MEMORANDUM

SUBJECT: G & M Short Plat SP-10-00005

Re: SP-10-00005

RE: G & M Parker Short Plat SP-10-00005

K.C.S.P. NO. 10-XXX
PTN. OF THE SE 1/4, SEC. 31 T.19N., R.18E., W.M.
KITTITAS COUNTY, WASHINGTON

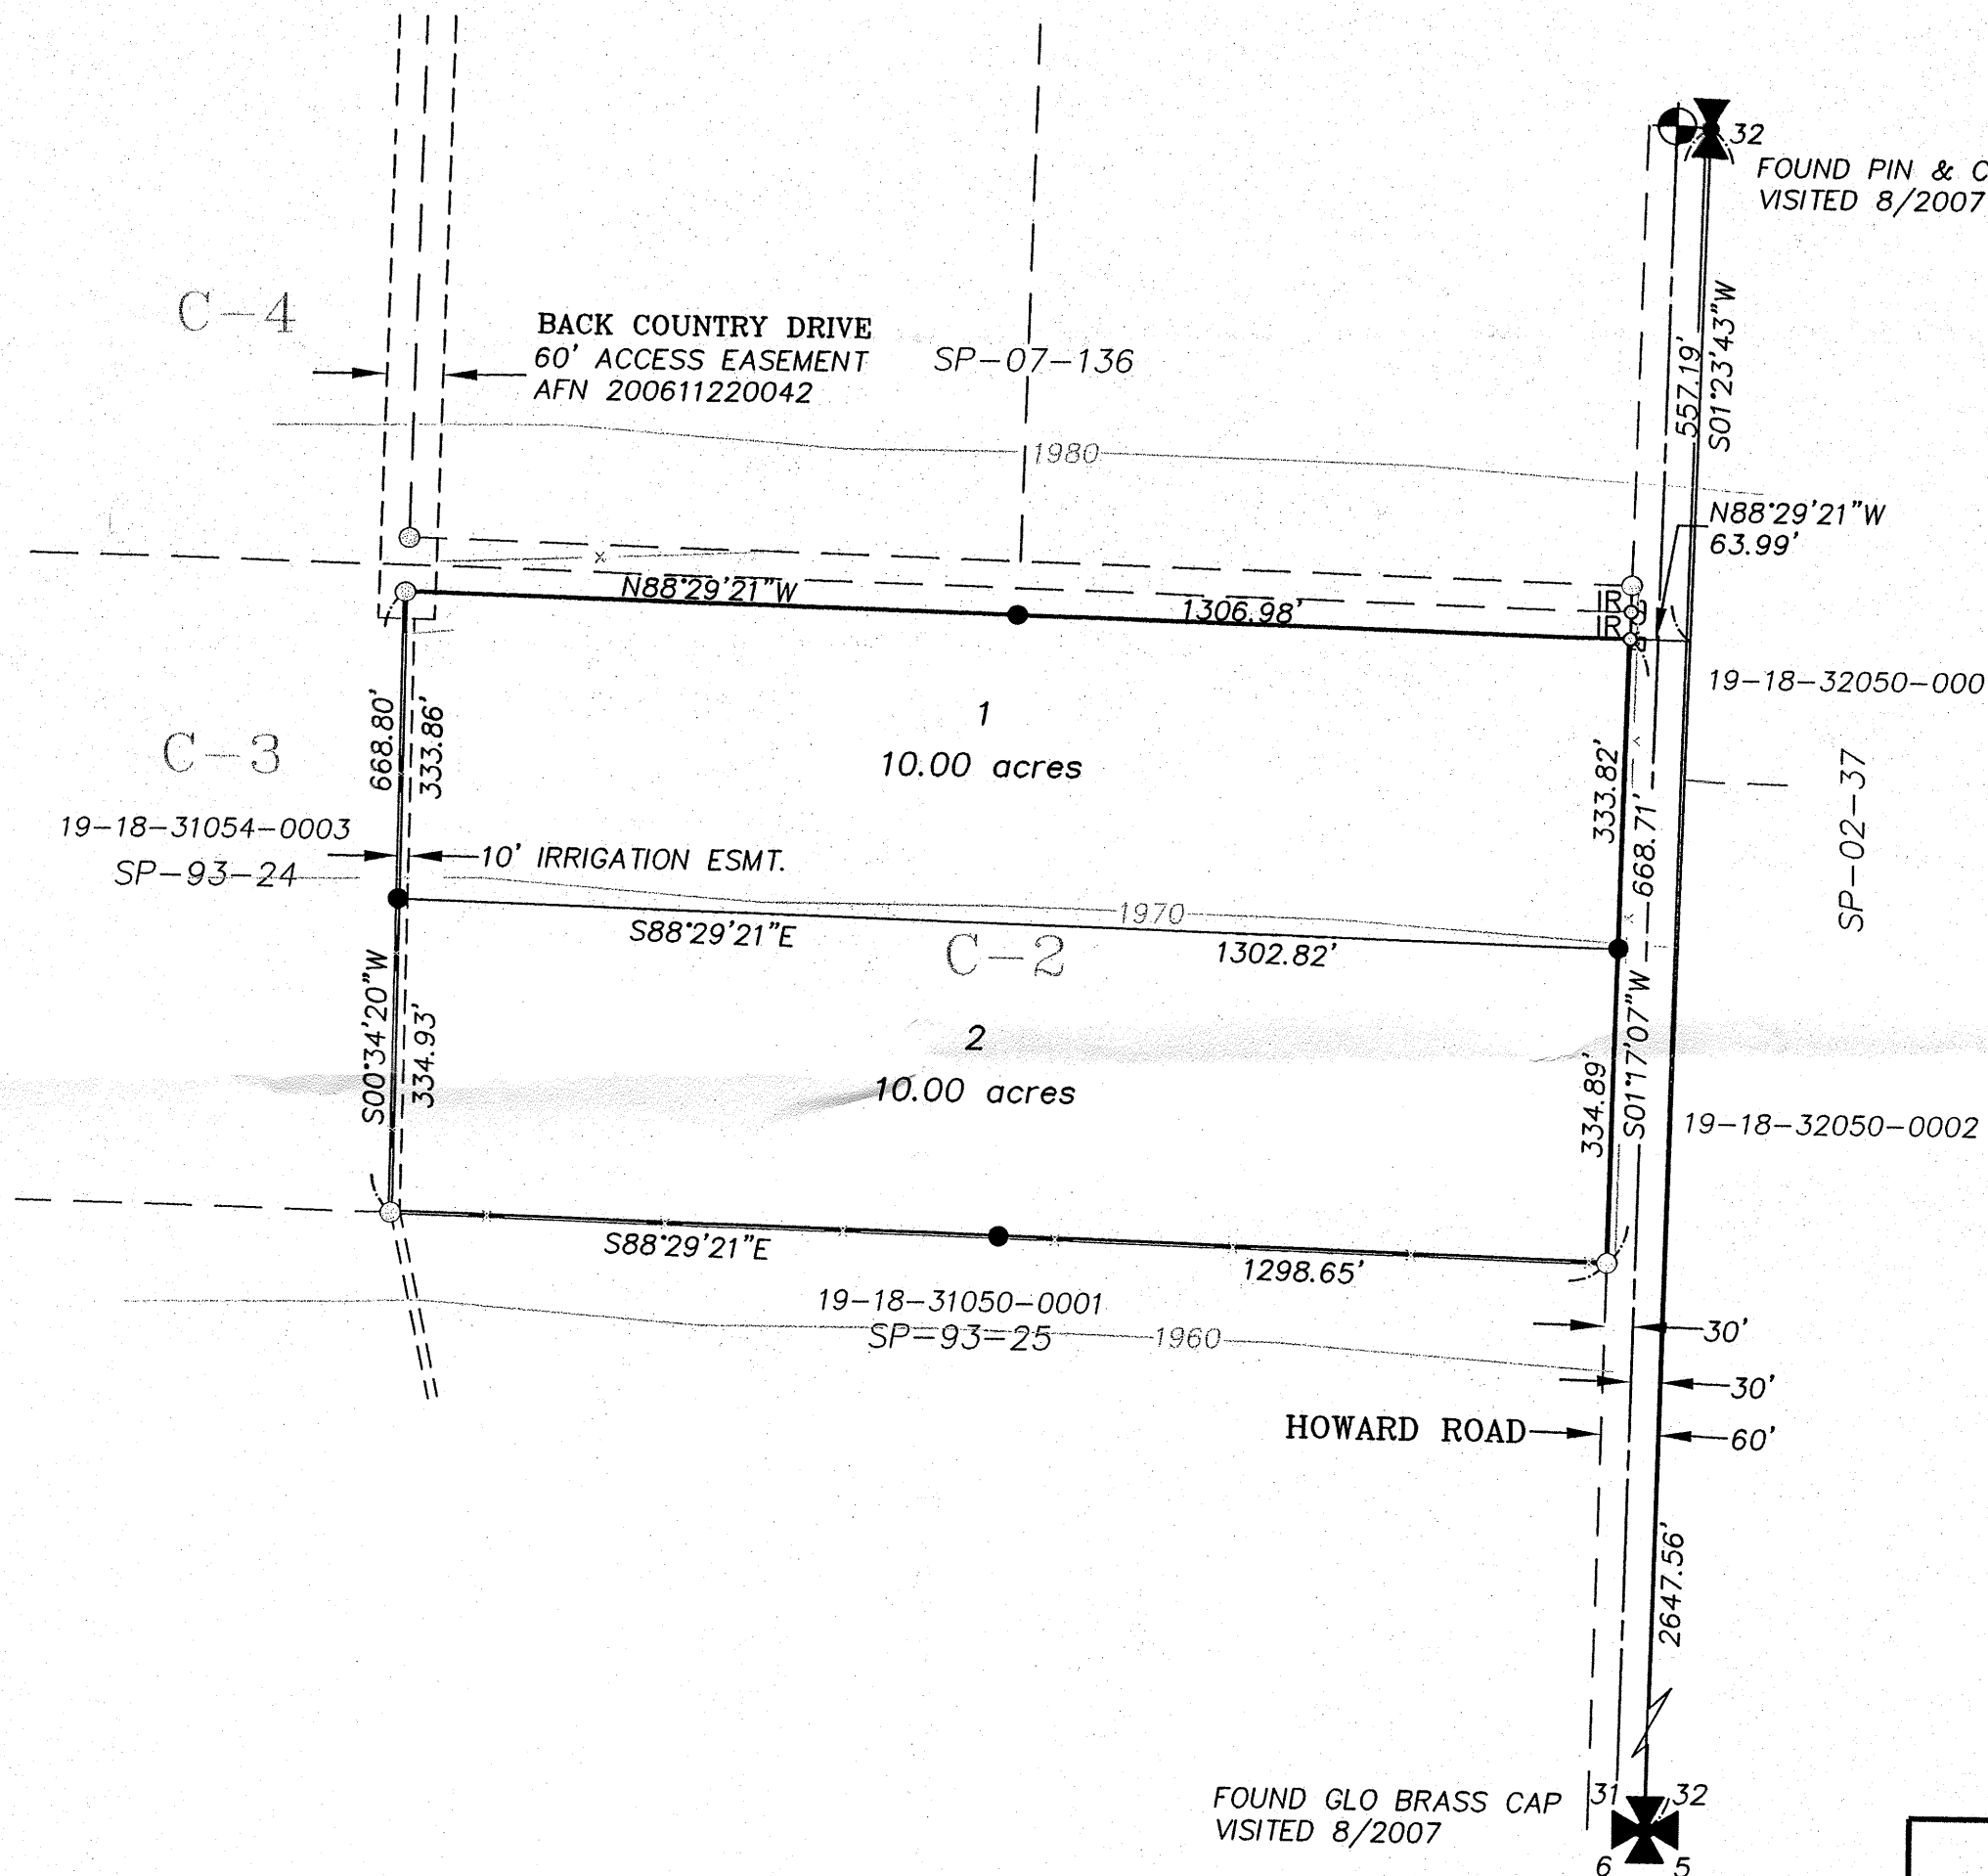
1. Joint-Use Driveway: A joint-use access shall serve no more than two tax parcels. See Kittitas County Road Standards, 9/6/05 edition.
 - a. Access easements shall be a minimum of 20' wide. The roadway width shall have a minimum width of 12'.
 - b. The surface requirement is for a minimum gravel surface depth of 6".
 - c. Maintenance of driveway approaches shall be the responsibility of the owner whose property they serve. The County will not maintain accesses.
 - d. Any further subdivision or lots to be served by proposed access may result in further access requirements.

Single-Use Driveway: A single-use access shall serve no more than one lot. See Kittitas County Road Standards, 9/6/05 edition.

- a. The roadway shall be a minimum of 8' wide with gravel surface.
 - b. Maintenance of driveway approaches shall be the responsibility of the owner whose property they serve. The County will not maintain accesses.
 - c. Any further subdivision or lots to be served by proposed access may result in further access requirements.
